Application No. **H16/0269/96**

**18M SERVICE STRIP INCORPORATED TO
PROVISING CLOSE SERVING PLOTS
17-19, 21-23.**

**ROAD ALSO RE-ALIGNED SERVING
ABOVE PLOTS AS REQUESTED BY
LCC HIGHWAYS.**

**Re: Proposed Residential Development Off Wygate Park, Spalding, Lincolnshire
Planning Ref : H16/0269/96**

PLAN 2.

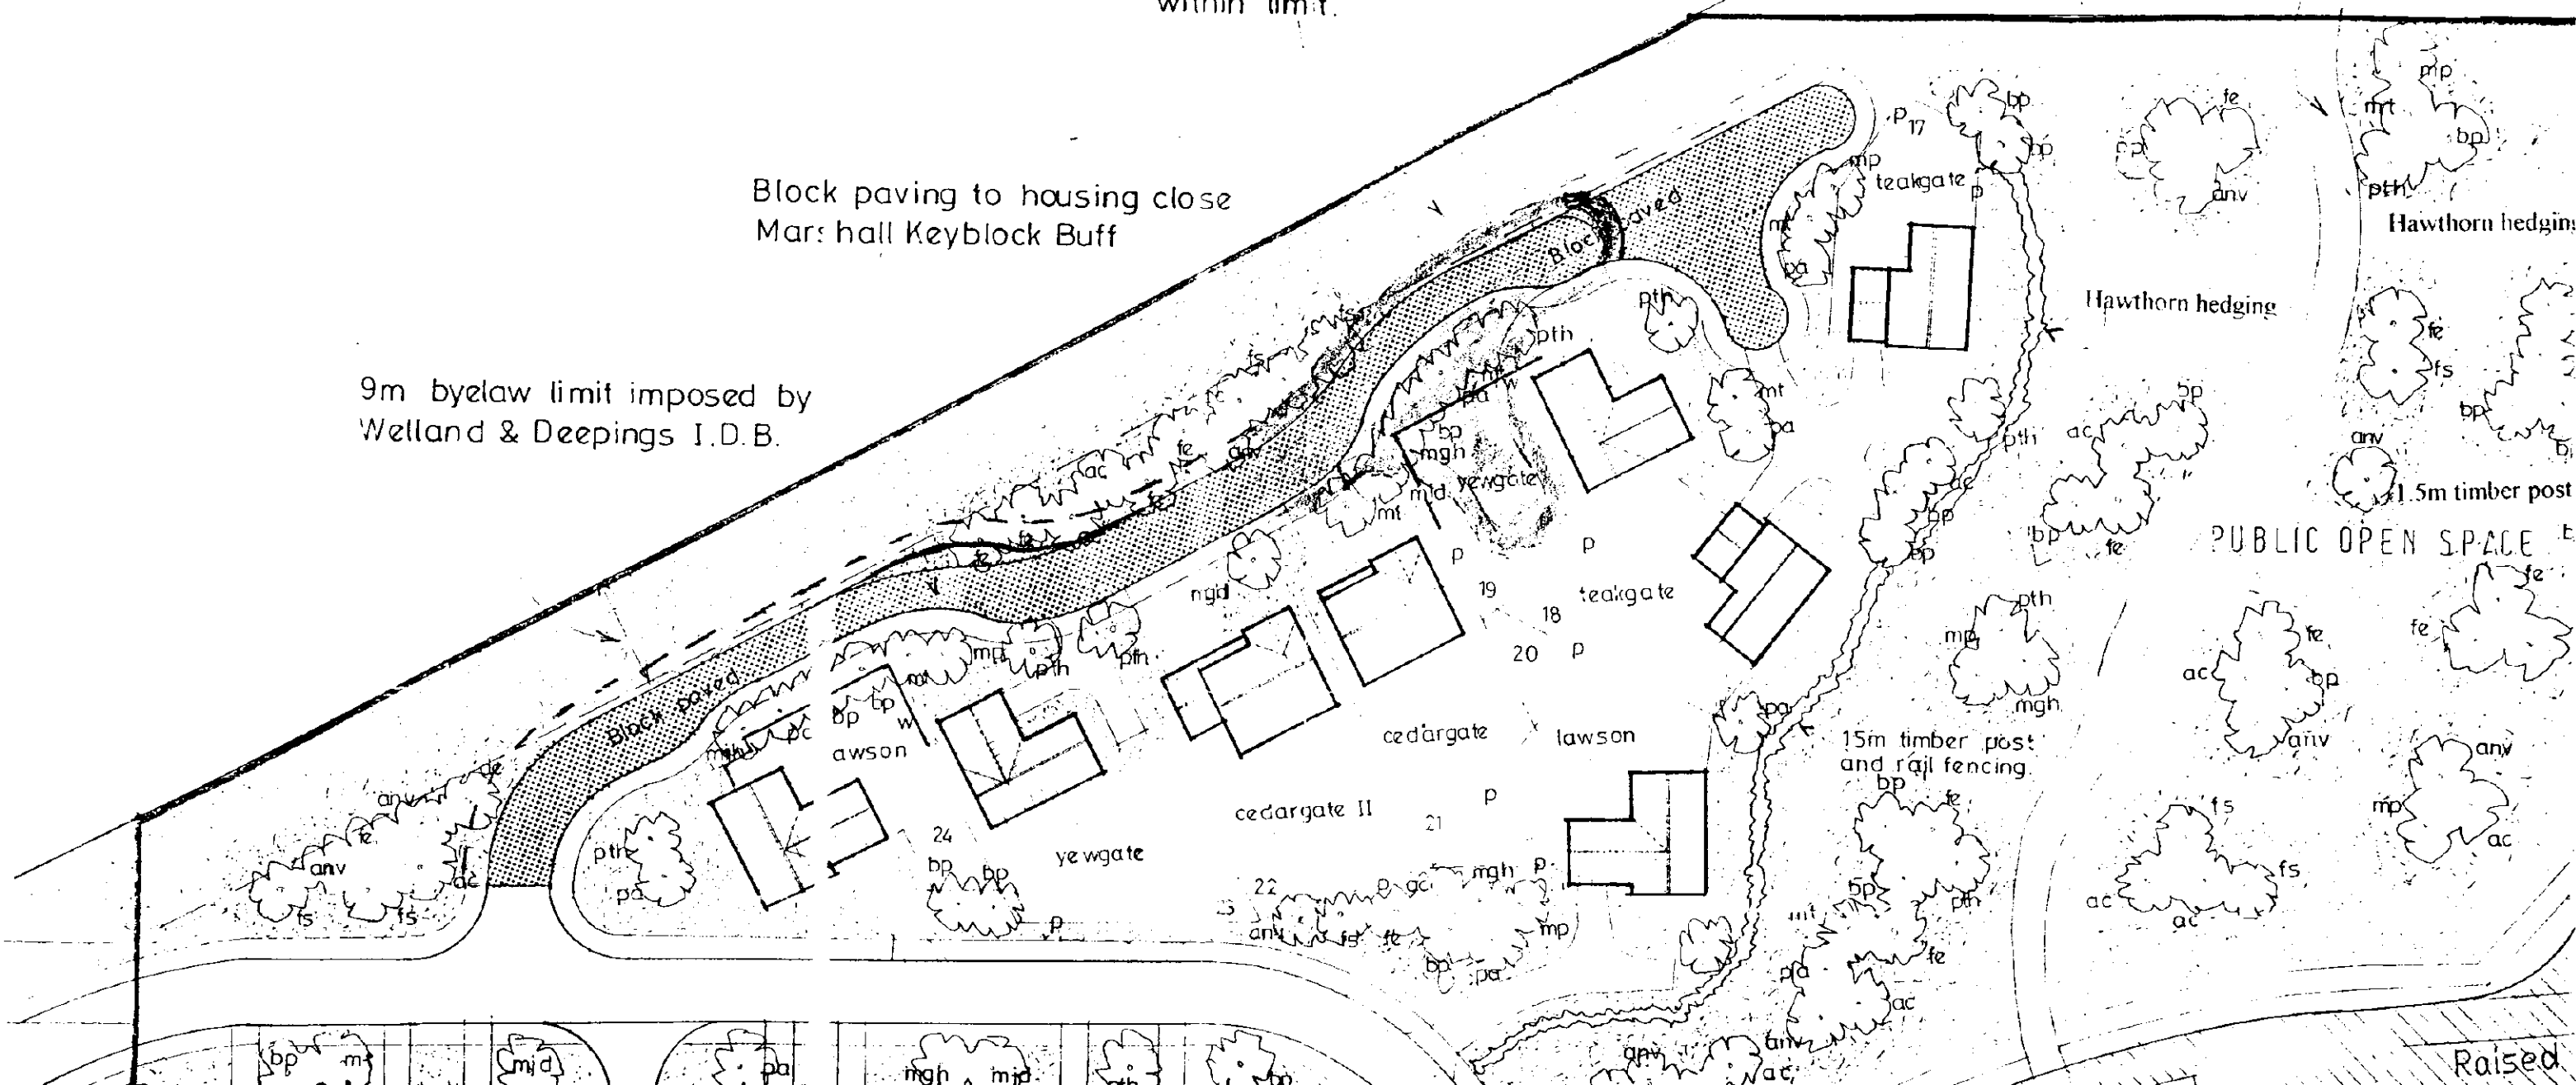
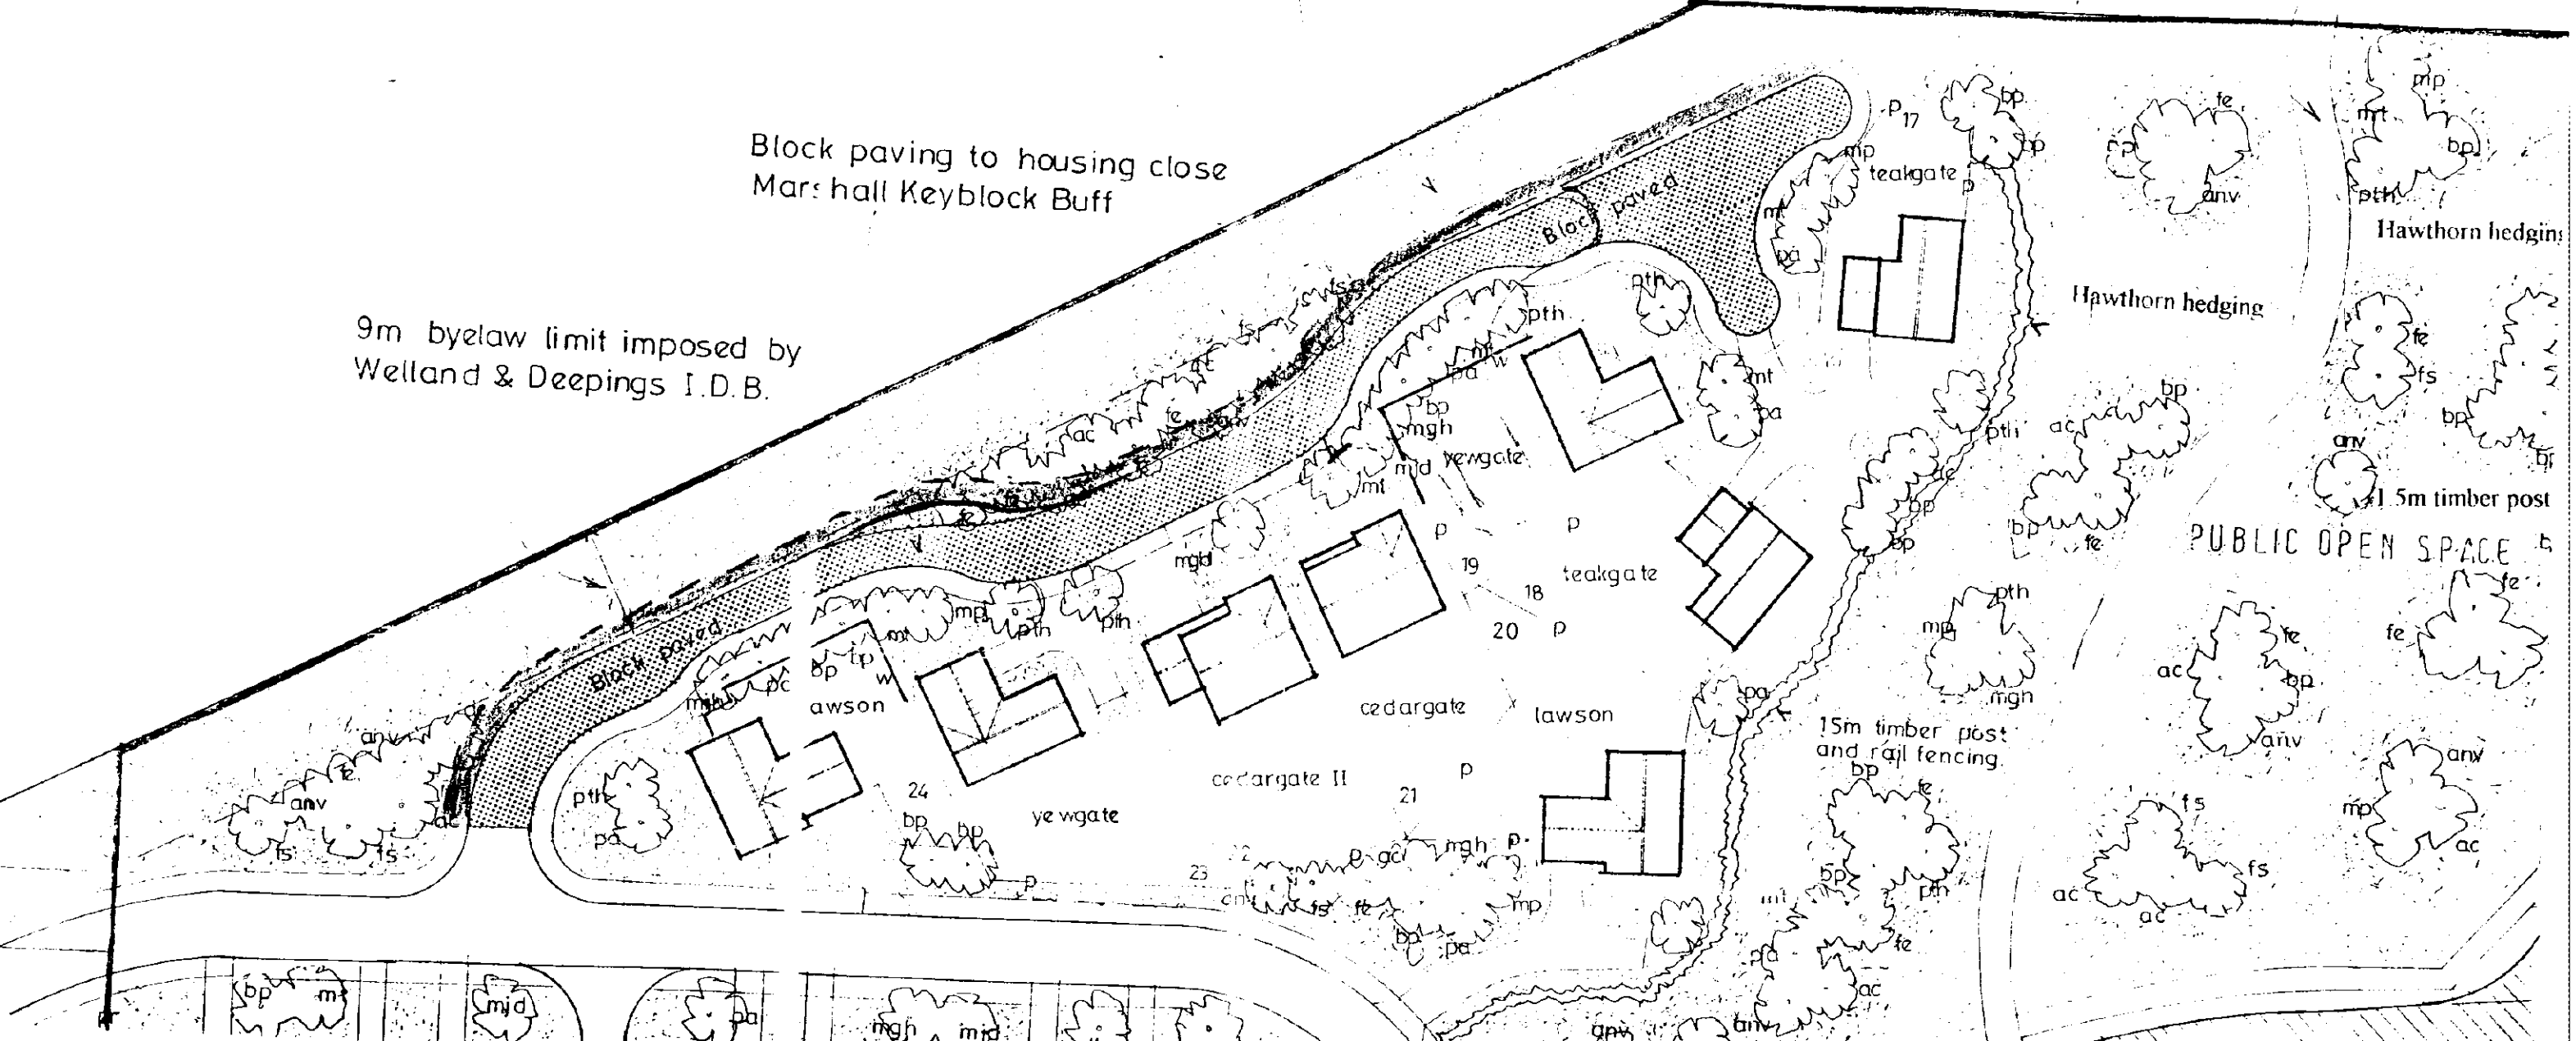
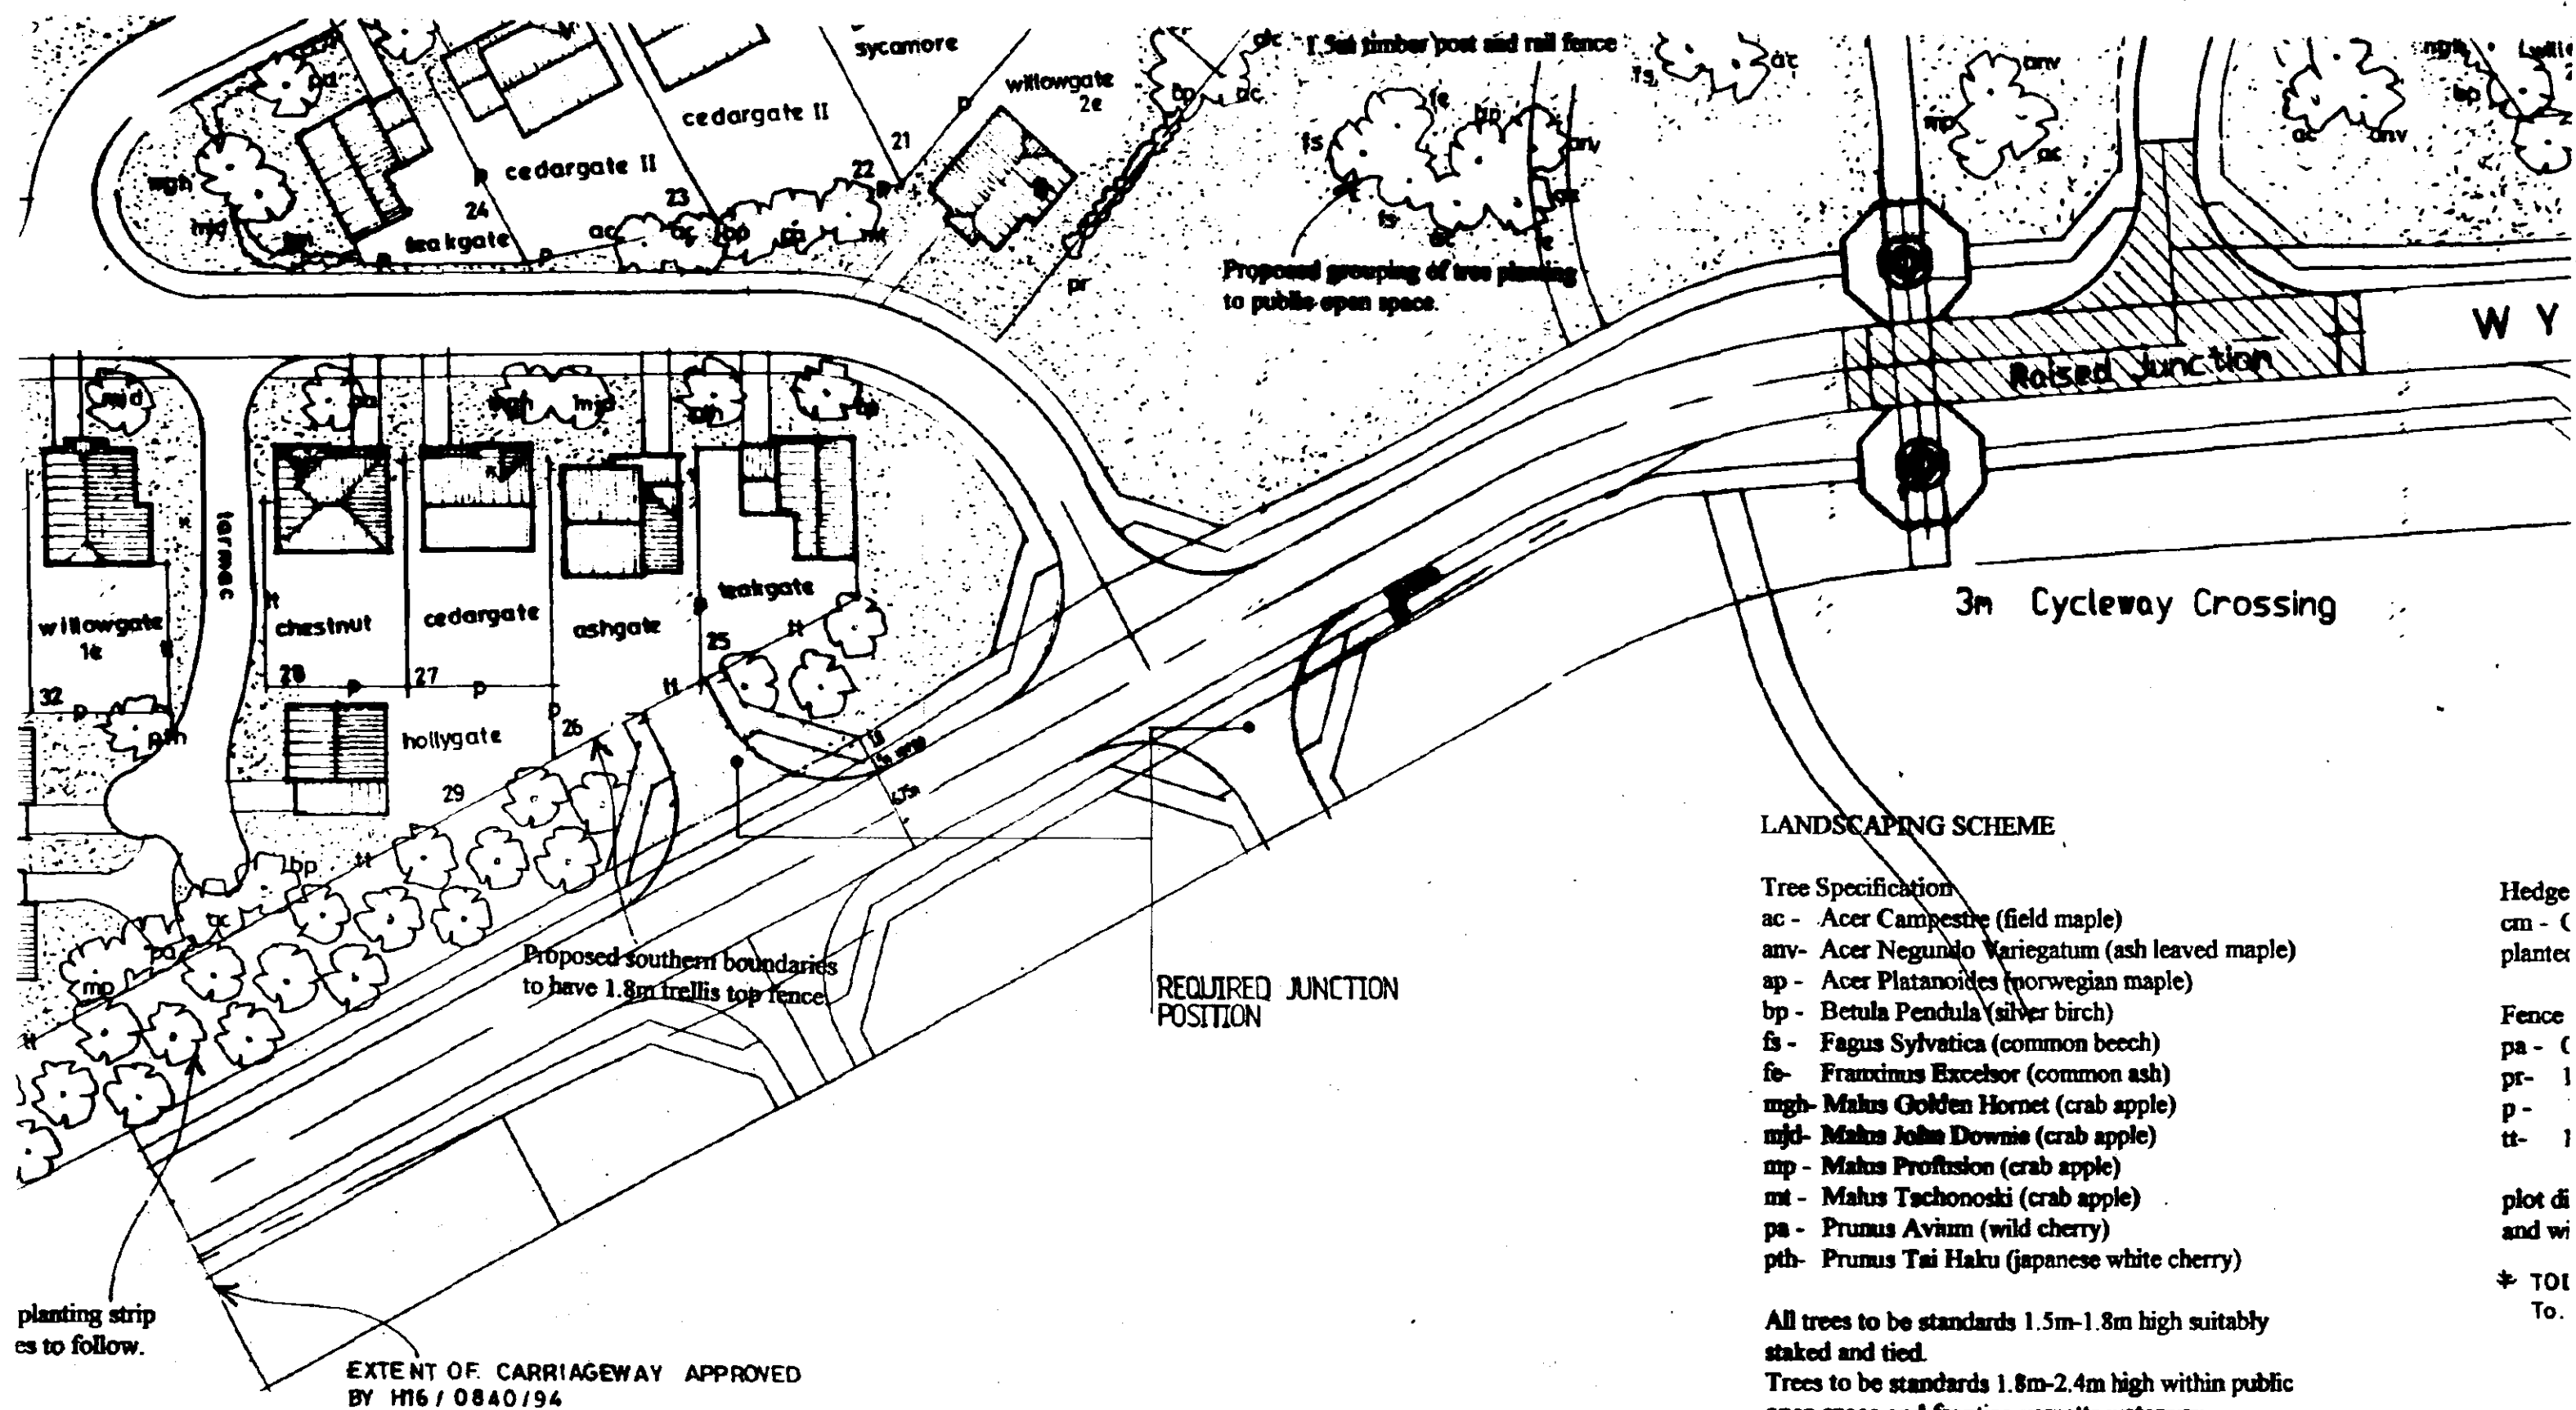
- 1-Housing close re-positioned and re-aligned not to fall within the 9m easement strip, as requested By the Welland And Deepings Internal Drainage Board.
No other construction, services or Tree and shrub planting can be proposed within that area.
